# CITY OF ALBUQUERQUE

April 11, 2024

**Re: Citizen Church North  
7518 Oakland Ave NE  
Request for Certificate of Occupancy- 30 Day Temp  
Transportation Development Final Inspection**  
Architects Stamp Date 10-24-22 (C19D005)  
Certification dated 2-27-24

SHEET NUMBER  
AS-1.0

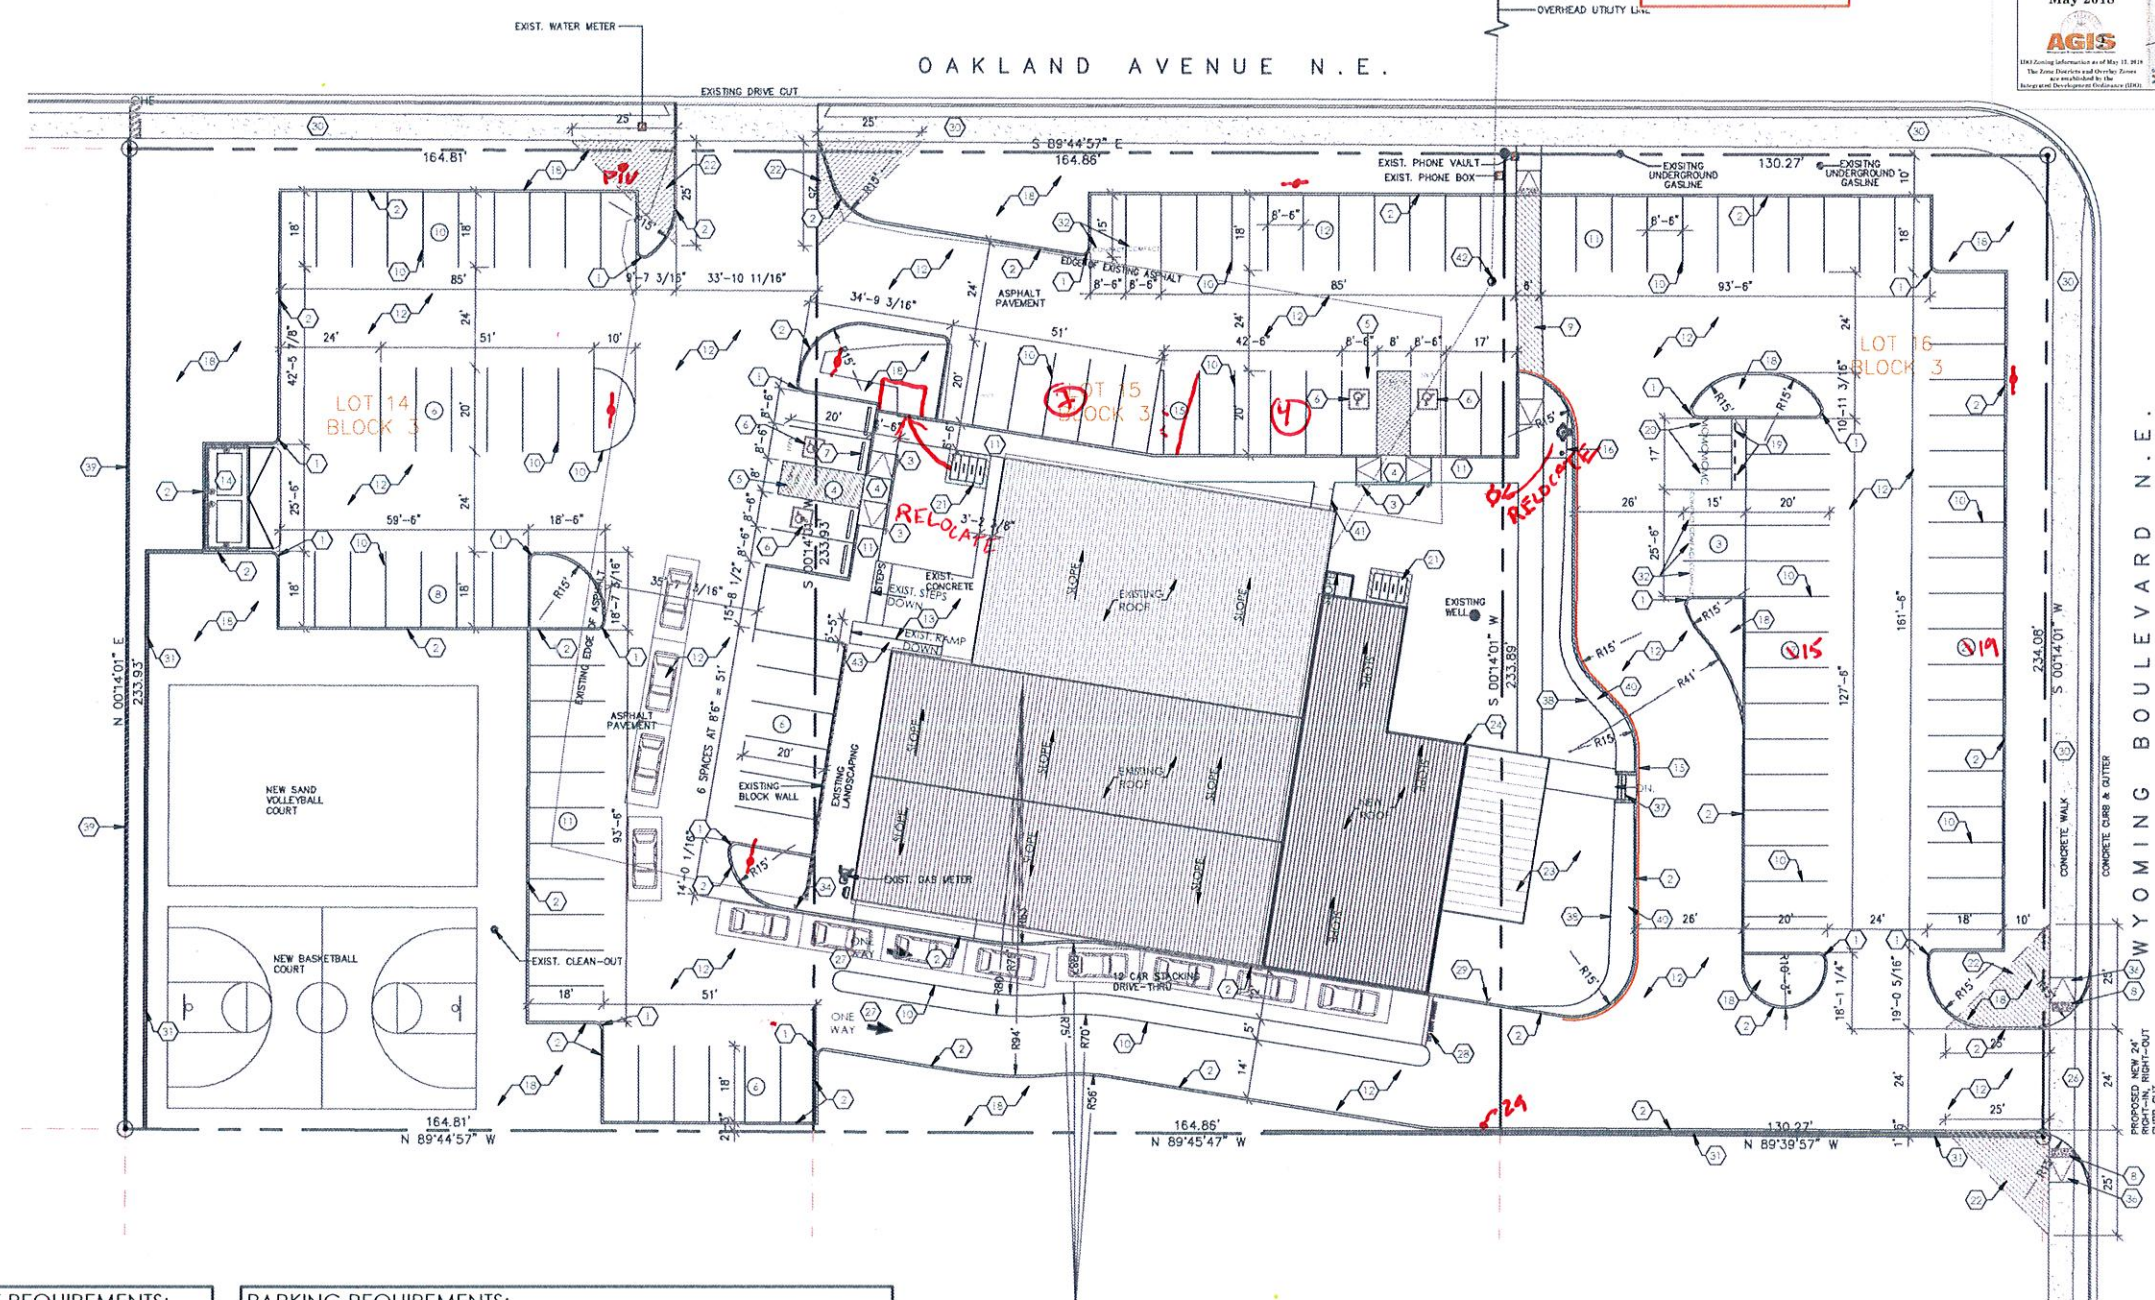
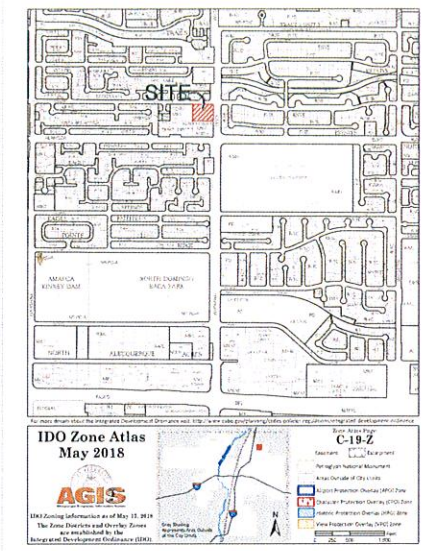
1. The bike racks were not installed.
2. The pedestrian connection to the Oakland Ave ROW was not complete.
3. The sidewalk culvert plate was not installed near the north side of the building.
4. There was material stored in the parking lot.
5. The mailbox west of the Oakland Ave entrance was too close to the sidewalk.
6. The landscaping was not complete so the public sidewalk could not be inspected.
